CITY OF ALBUQUERQUE

July 5, 2013

**Re: Murphy Express, San Mateo Blvd. and Zuni Rd.
Grading and Drainage Plan
Engineer's Stamp Date 5-31-13 (L18/D079)**

GRADING AND DRAINAGE PLAN

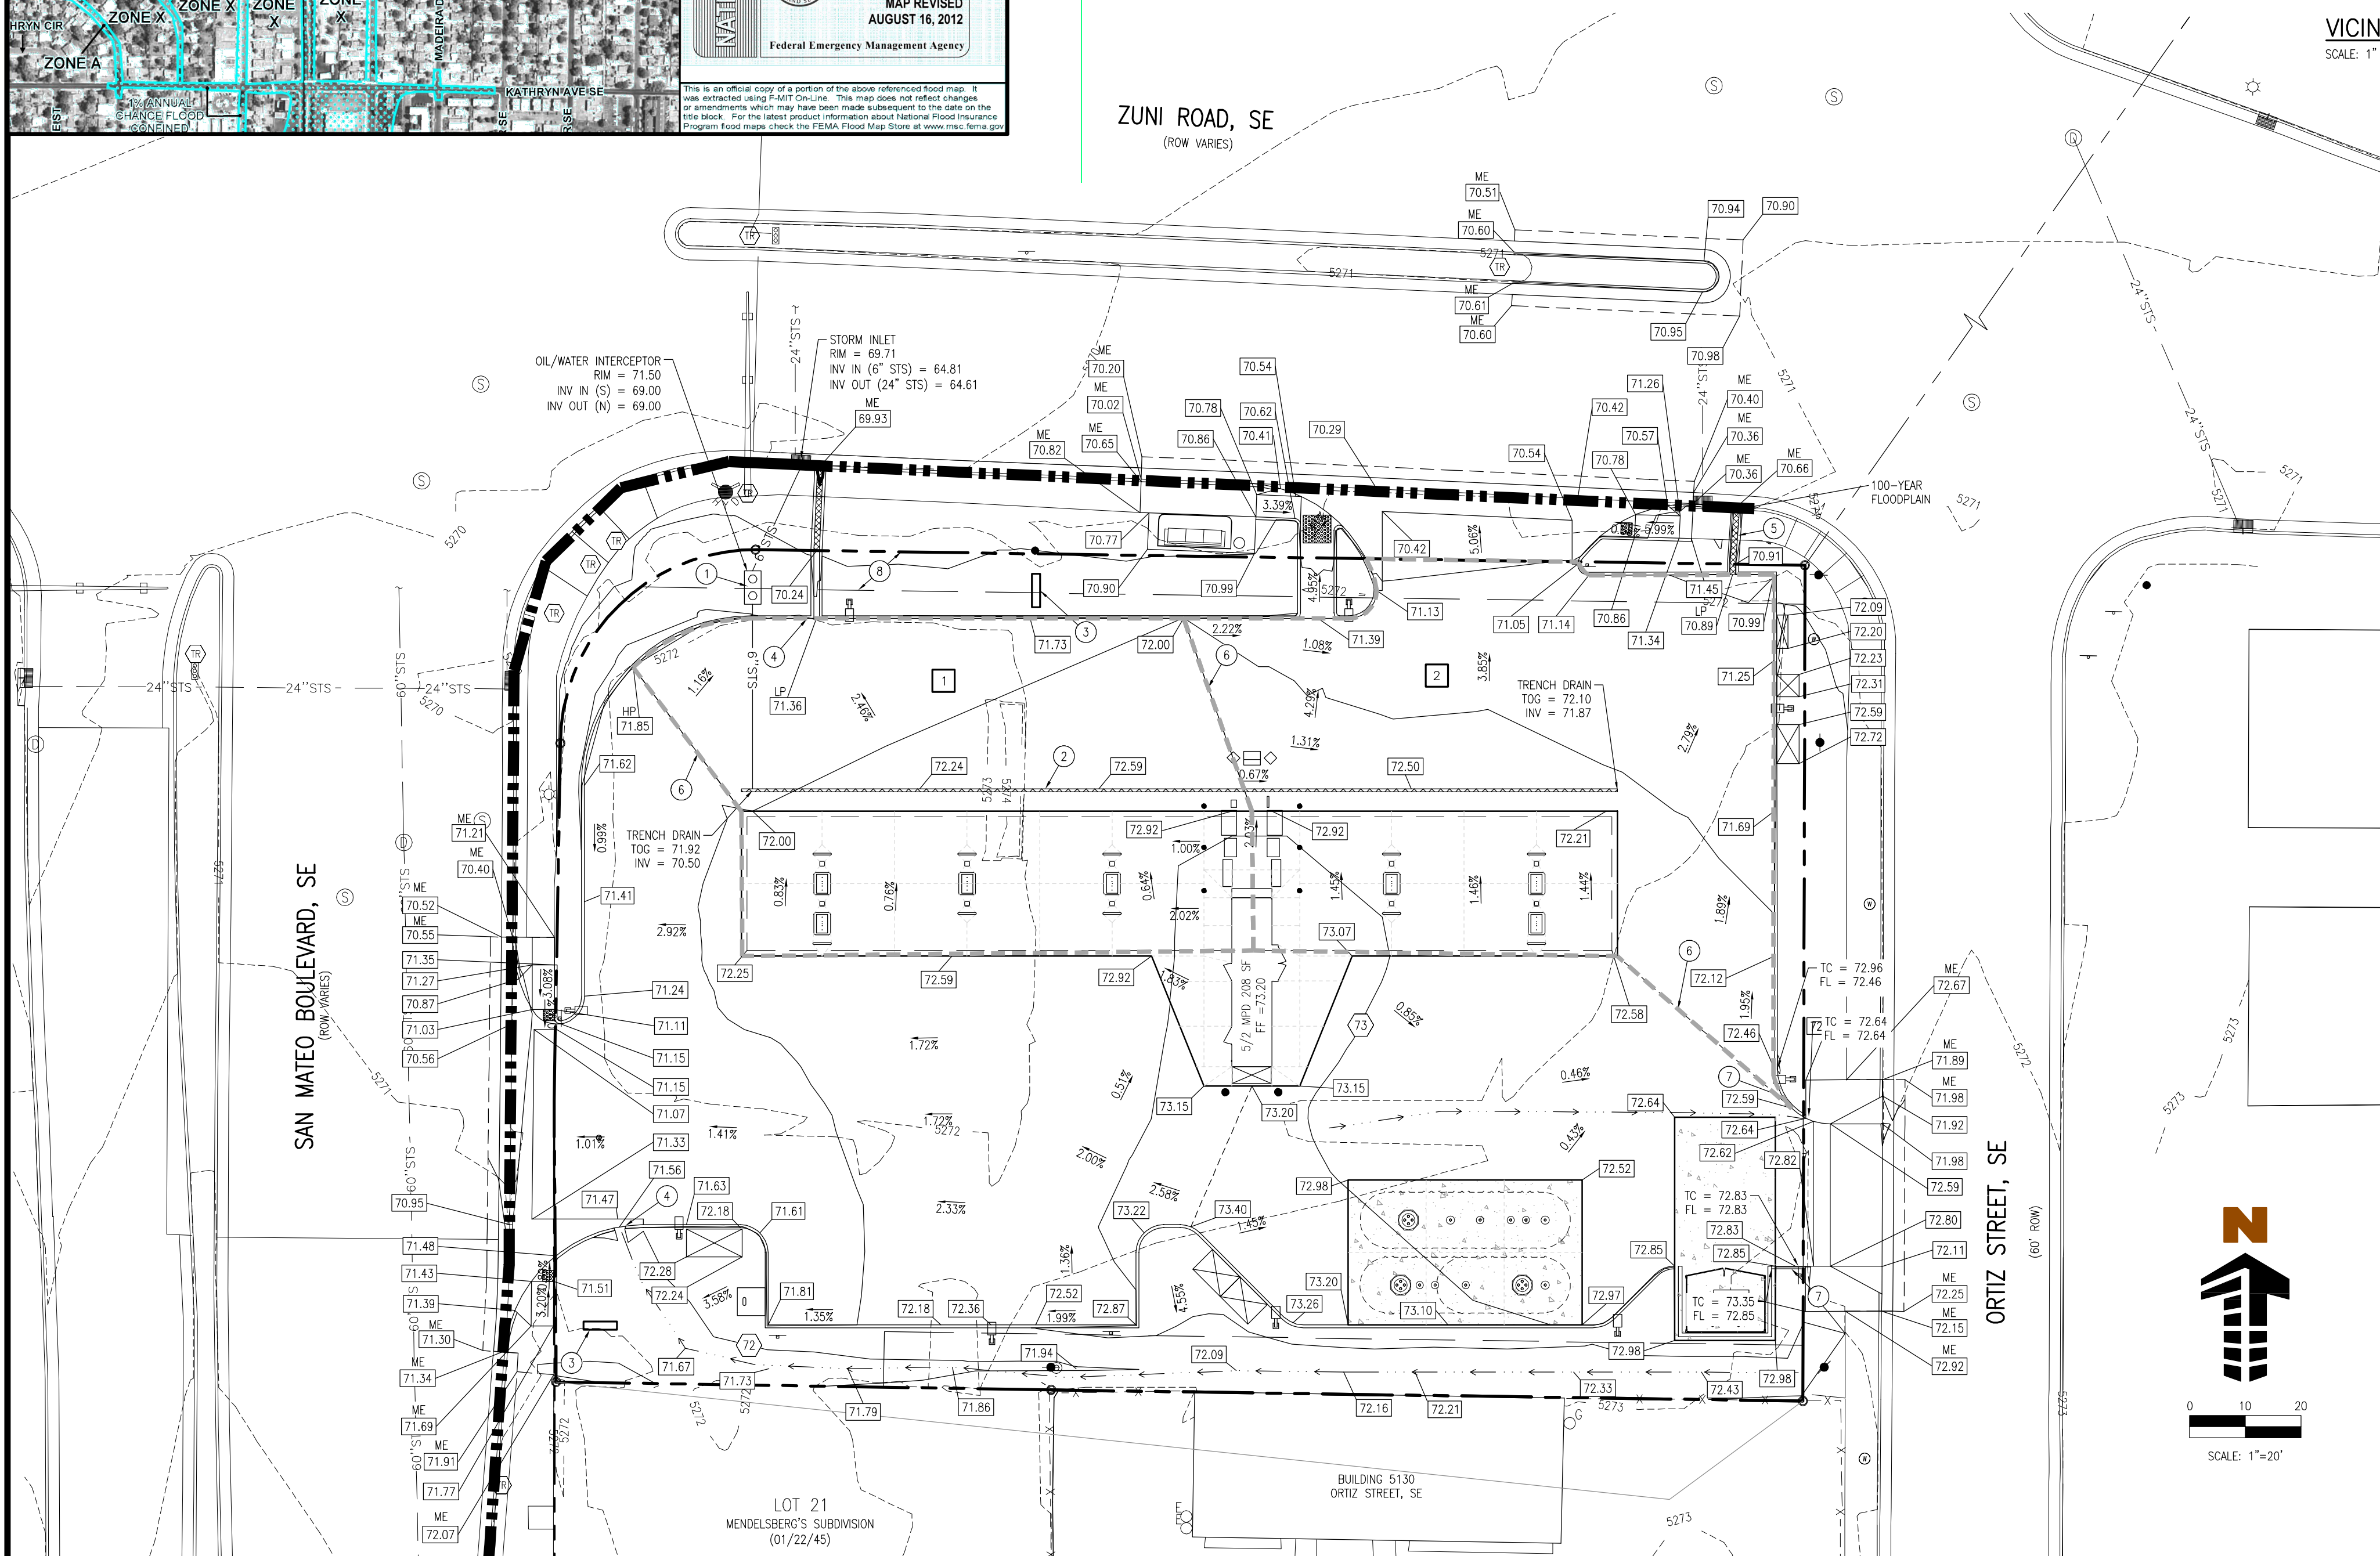
- Please provide runoff calculations under the existing and proposed conditions.
- Sidewalk culverts including the plate should be extended to the property line. If the sidewalk is against the property line the sidewalk culverts including the plate should be extended 2' beyond the property line. Call out the City Standard Drawing # 2236 for the construction of the sidewalk culvert. Include a note under the sidewalk culvert that the blots must be tack welded at the plate.

- Provide the trench drain detail on the plan. Include the inverts at both ends of the trench drain. Include all the inverts and pipes sizes from the trench drain to the oil/water separator, and to the storm drain inlet.

- Provide the size of the oil water separator on the plan. Hydrology has adopted a 500 gallon minimum oil/water separator.
- Include all curb opening sizes and calculations.

- Runoff to the west side of the project drains to the landscaping area and over the sidewalk to San Mateo Blvd. Runoff can not drain over the sidewalks into the streets.

- Runoff must be routed within the property. For the area to the east the runoff drain to the right-of-way (an area between the sidewalk and property line) and back into the site. The area between the sidewalk and property line are typically sloped at 2% to the street.
- Include a note on the plan to depress the landscaping areas were possible (for the landscaping areas within the property).
- Is there any offsite runoff from the south that may enter this site?
